Our reference: ECM: 9598535
Contact: Kathryn Saunders
Telephone: (02) 4732 8567

9 June 2021

Response to Request for Advice on SEAR's Request: Oakdale West Estate, Warehouse 4E at 2 Aldington Road Kemps Creek

4E Site & Warehouse Plan

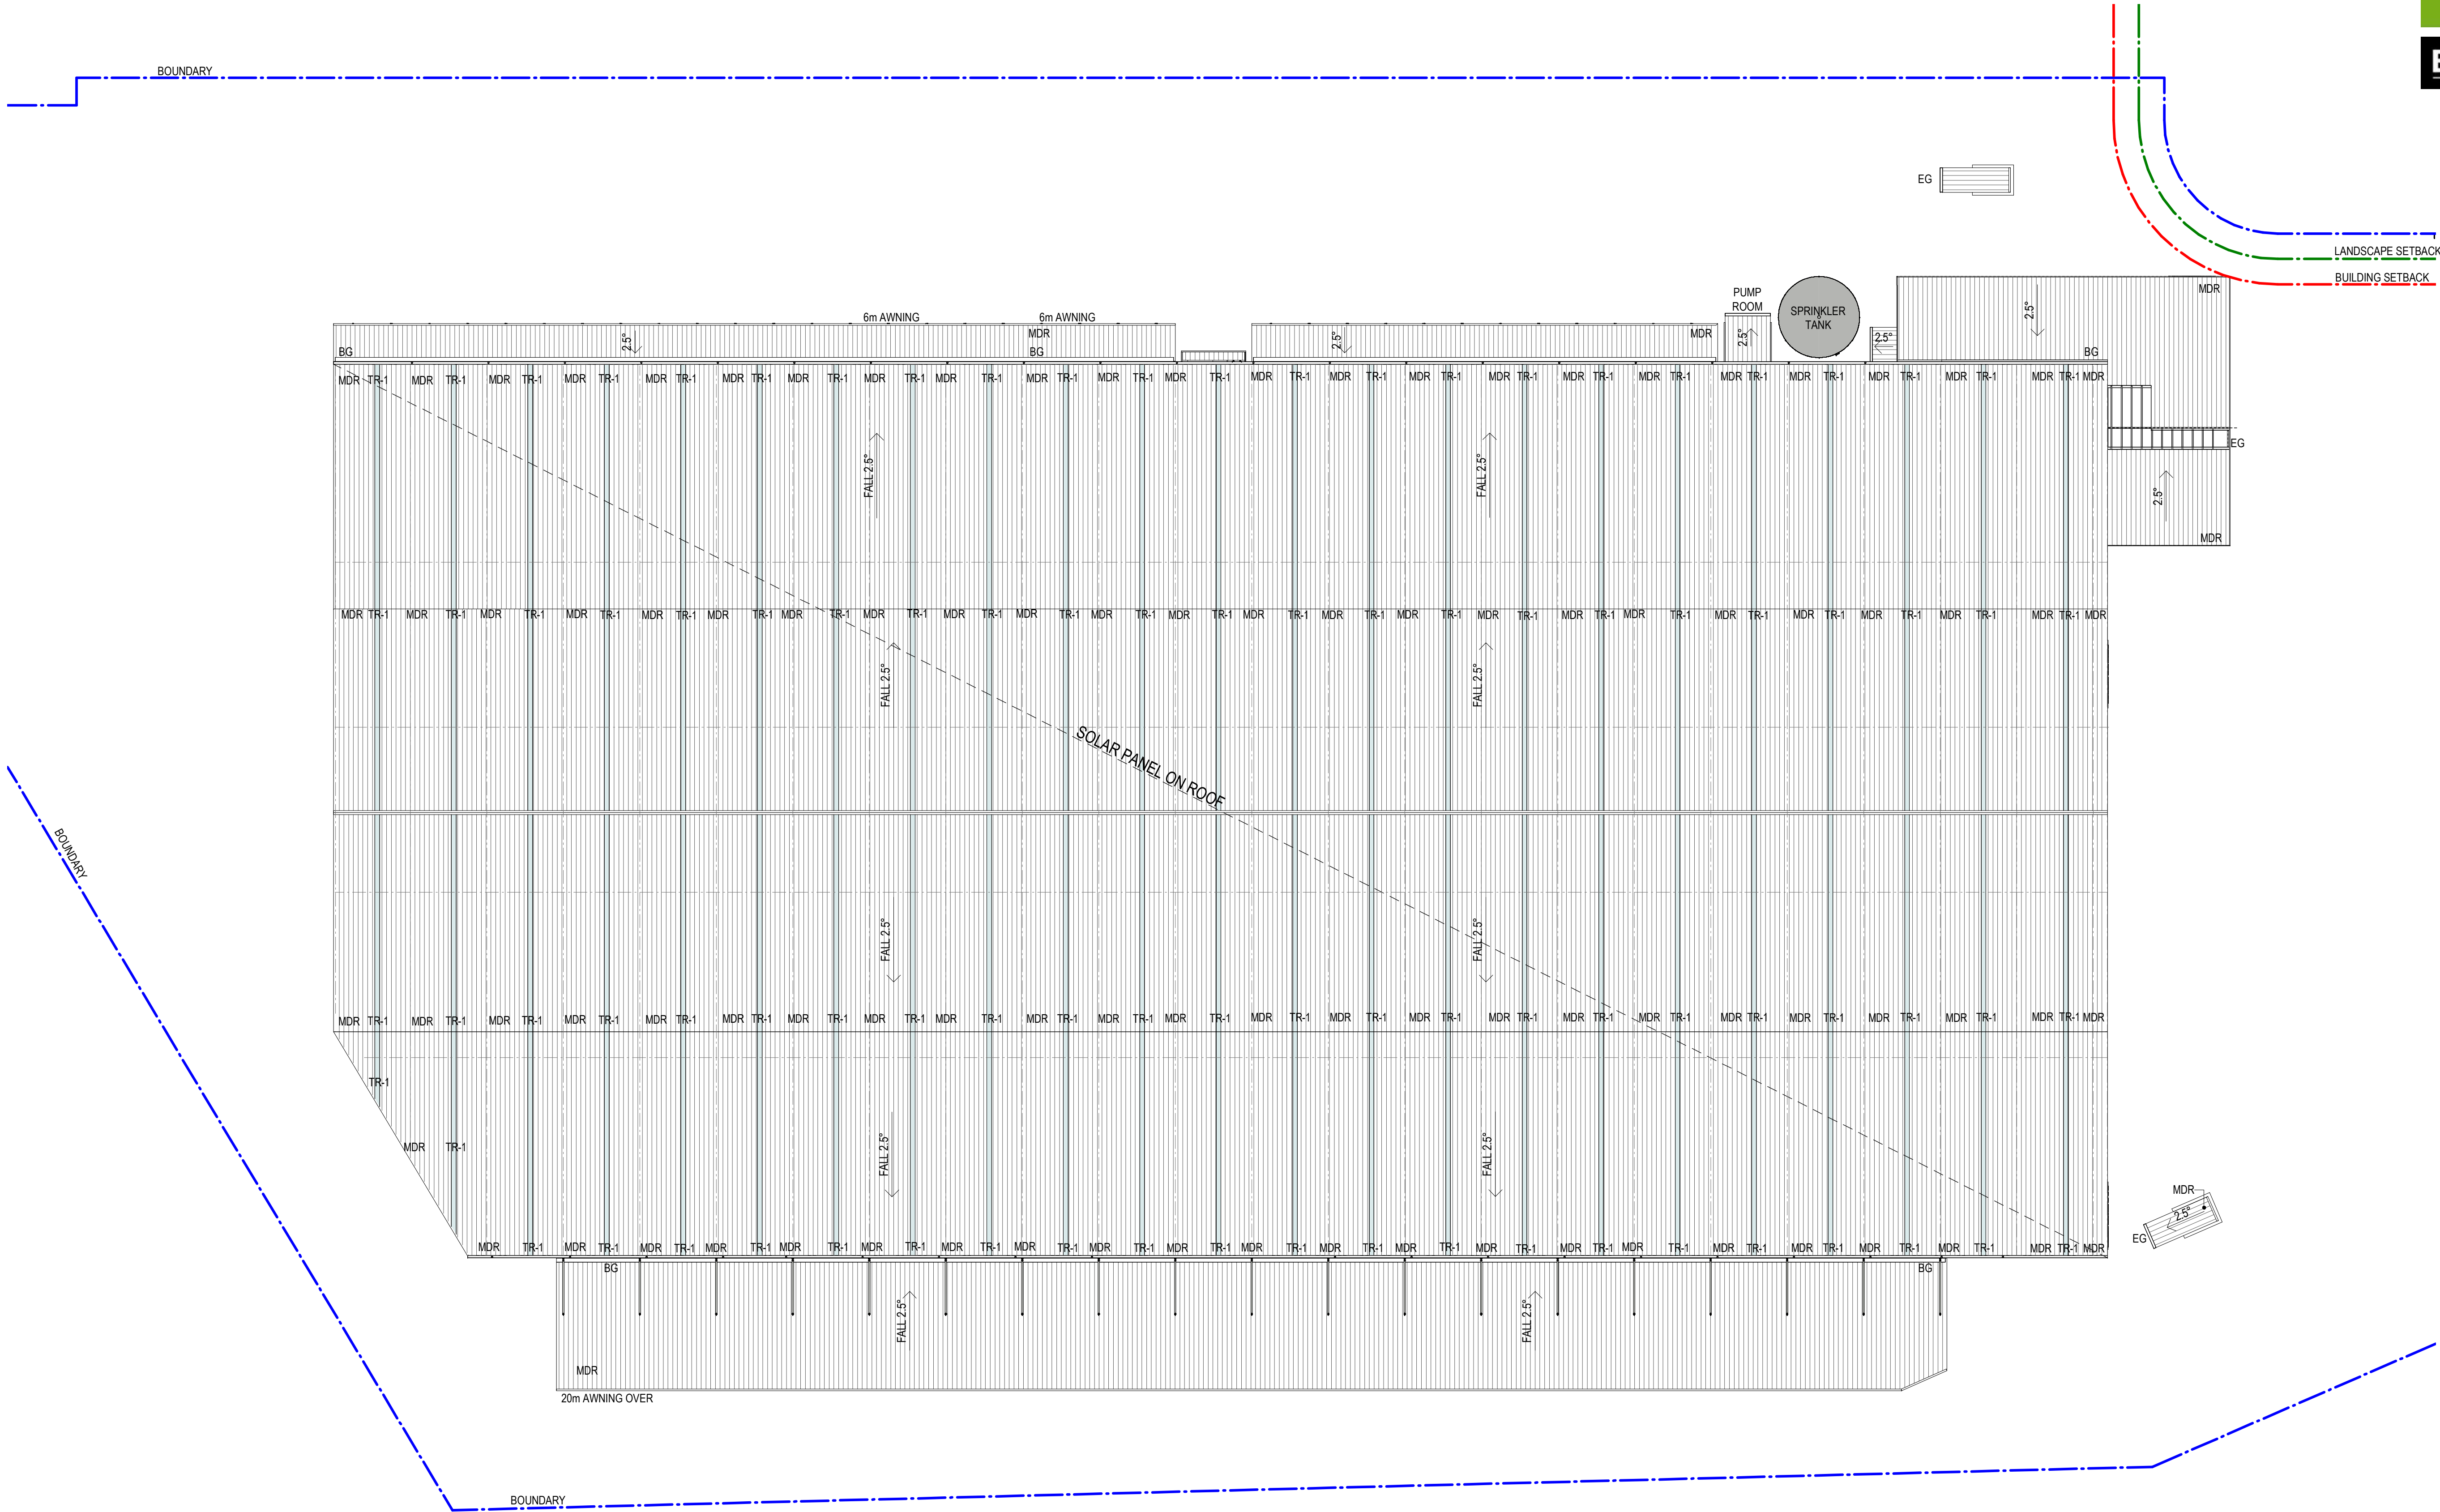
In relation to the design and layout of the warehouse development, landscaping setbacks are to be maximised and owing to the limited frontage of the site to the Estate Road, are not to be encroached upon.

It is noted that car parking provision generously exceeds the minimum requirements of the applicable rates and thus it is strongly recommended that internal landscaped blisters within the car parking areas are increased in width and area so that long term sustainable and significant canopy tree planting can be accommodated and will thrive.

Landscaped blisters within car parking areas shall be included at a rate of one every 6 car parking spaces and are to be a minimum of 2m in width. Soil volumes are to be maximised and WSUD features are to be integrated into the car parking and landscape design (refer images below).

A central landscaped aisle is suggested, and as a minimum, car parking aisles are to be bookended and interspersed with larger and more significant landscaped blisters or islands to ensure sustainability of shade producing canopy trees.

All retaining wall locations and top of wall heights are to be nominated on the set of architectural and landscape plans.

Pad mounted substations and all other services such as hydrant boosters are to be nominated on plans and landscaping is to be increased rather than deducted from to accommodate the service infrastructure.

An outdoor staff lunch or break area is to be provided and is not to be nominated as 'smokers shelter'. The outdoor staff area should be high in amenity and not co-located with the pump room and sprinkler tank – or is to be screened.

Services such as the pump room and sprinkler tank should be screened from the street or located away from the primary entry and street front. The area hatched as green surrounding the sprinkler tank and pump room is unlikely to be landscaped owing to the hardstands required. Plans should be realistic as to the extent of landscaping provided.
